August 27, 2010

**Project Name:** Office Expansion;  
Poulin Property Holdings LLC and Poulin Financial  
Services LLC, PA, Joint Applicants

**Project Address:** 171 Warren Avenue, Portland Maine

**Project ID:** 10-79900021

SITE PLAN

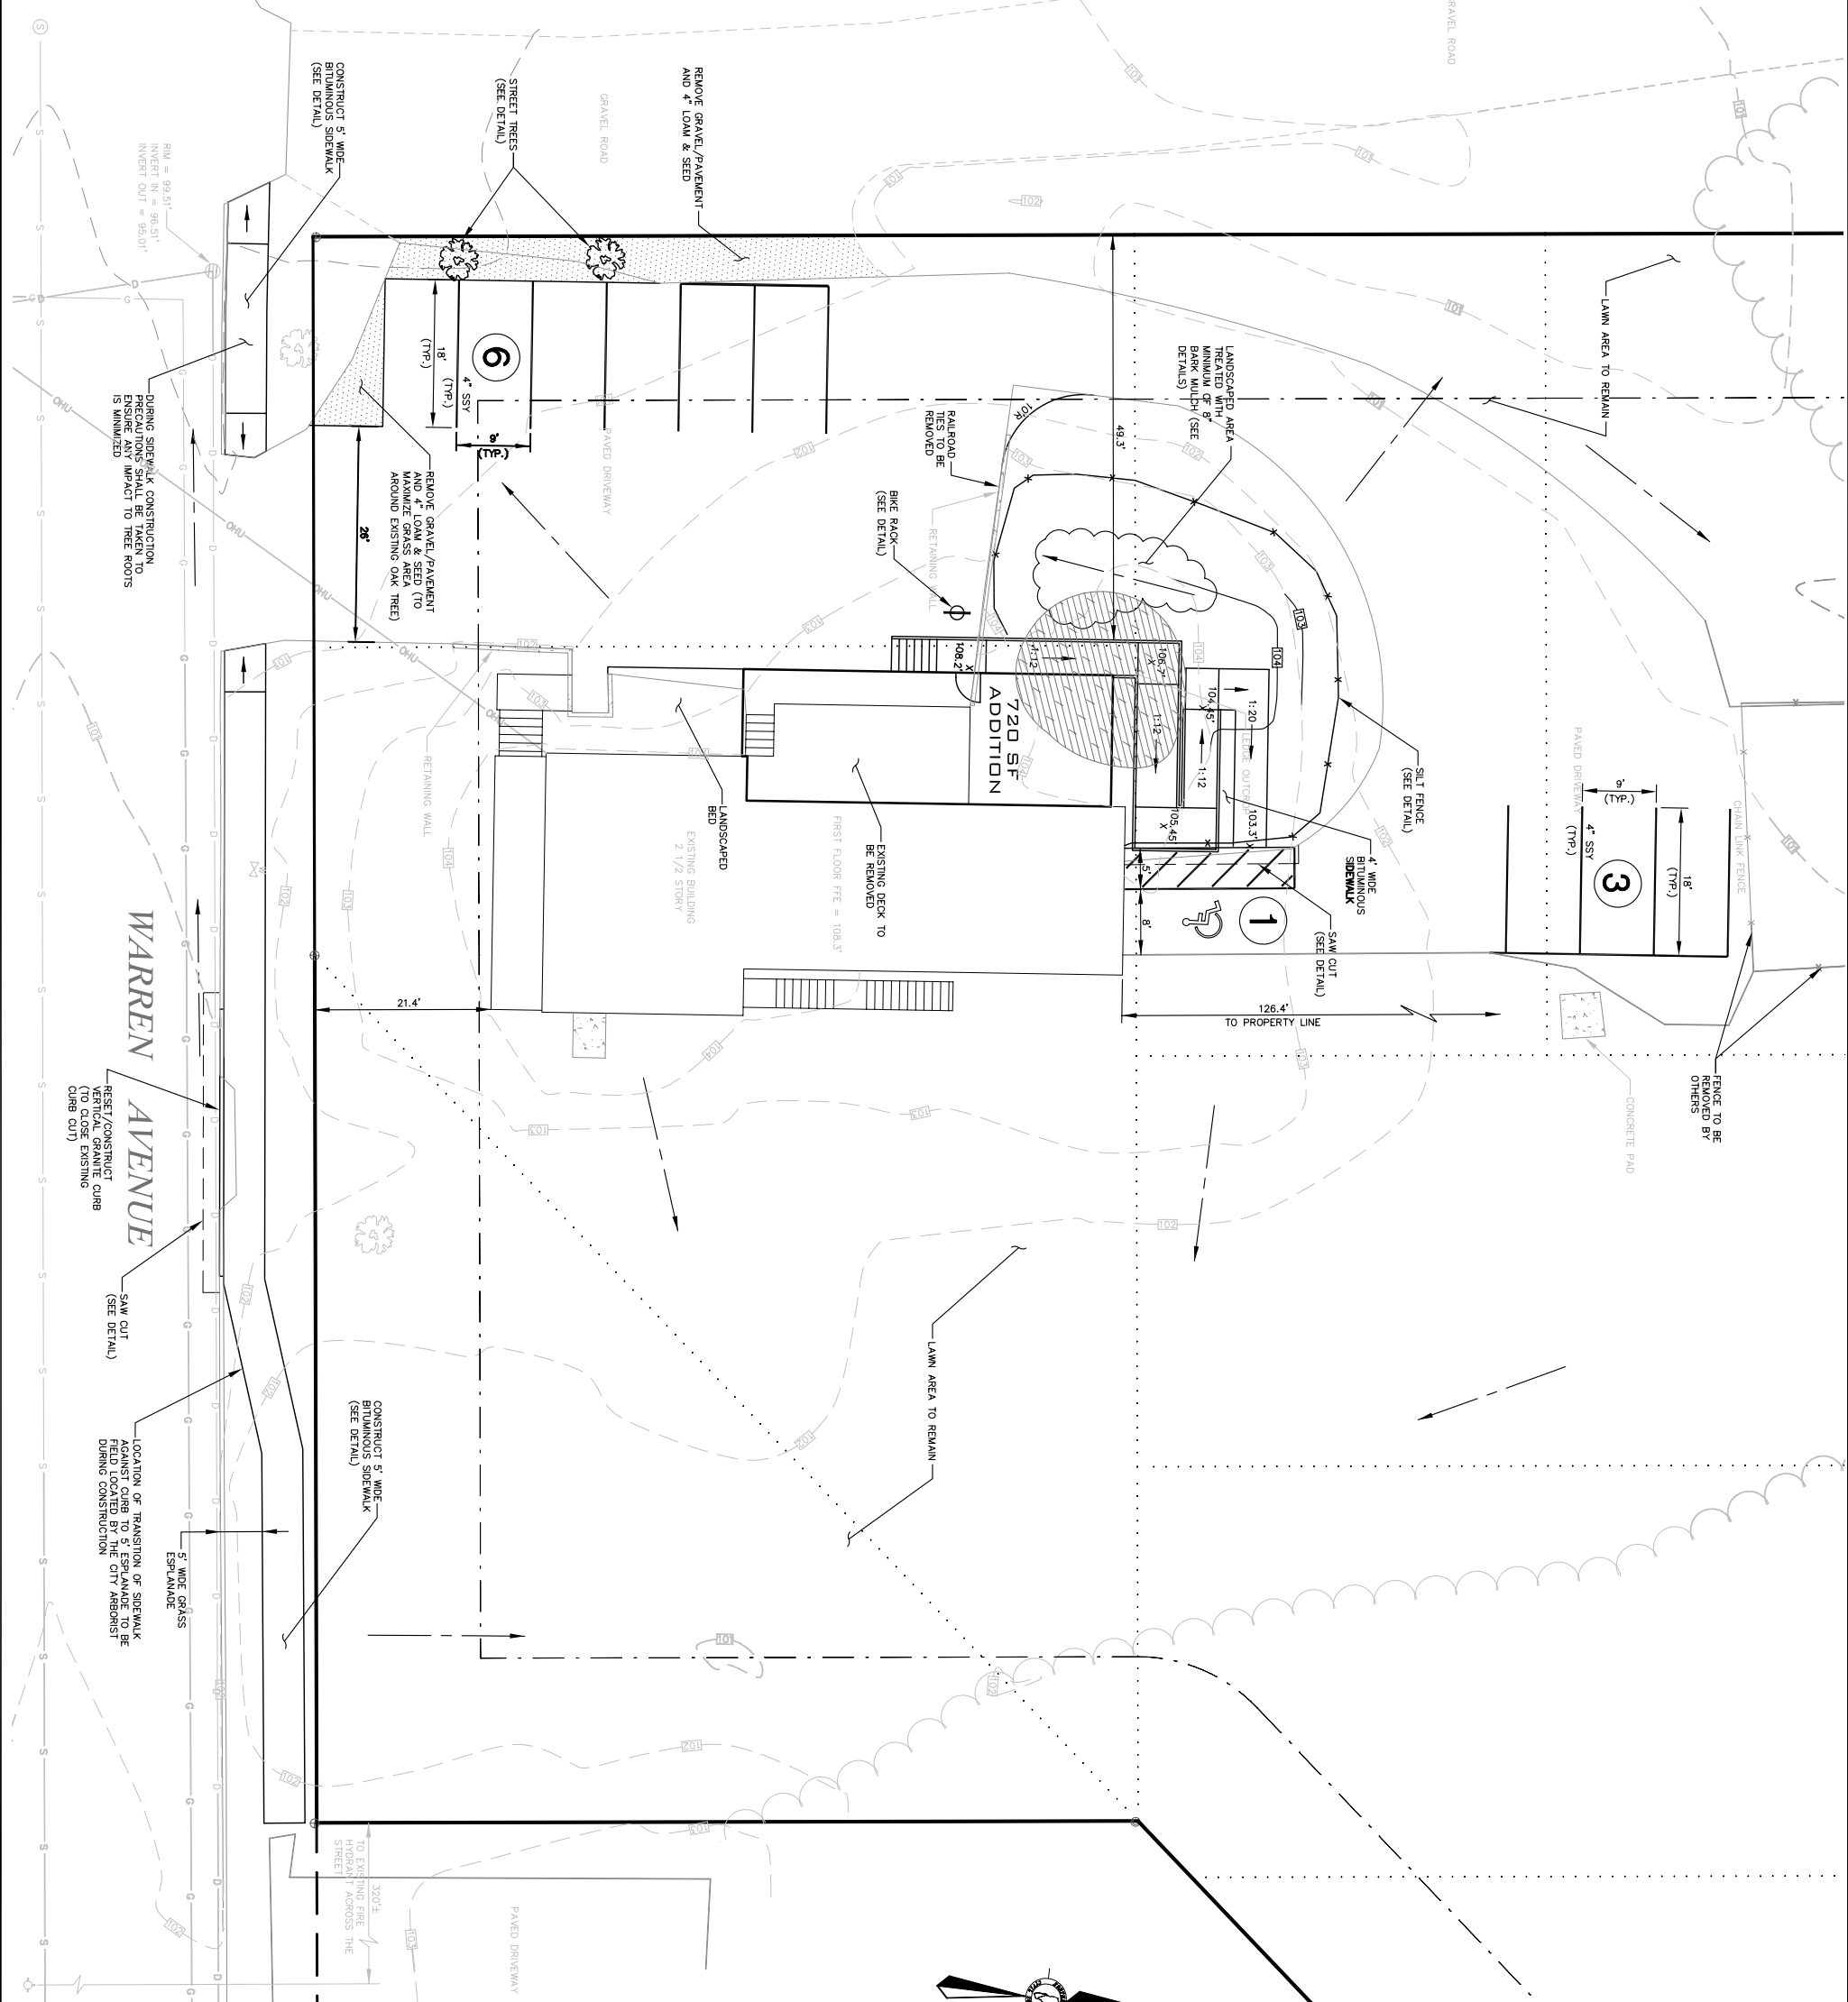
- iv. That if in the future a dumpster or any exterior lighting (including building mounted) is proposed for installation on this site, the applicant shall submit plans and details of such items for review and approval prior to their installation; and
- v. That all pavement repairs within Warren Avenue, which is classified as a City arterial, shall meet the requirements of the City Technical Manual detail for an arterial street and not as shown in the detail on the submitted plans.
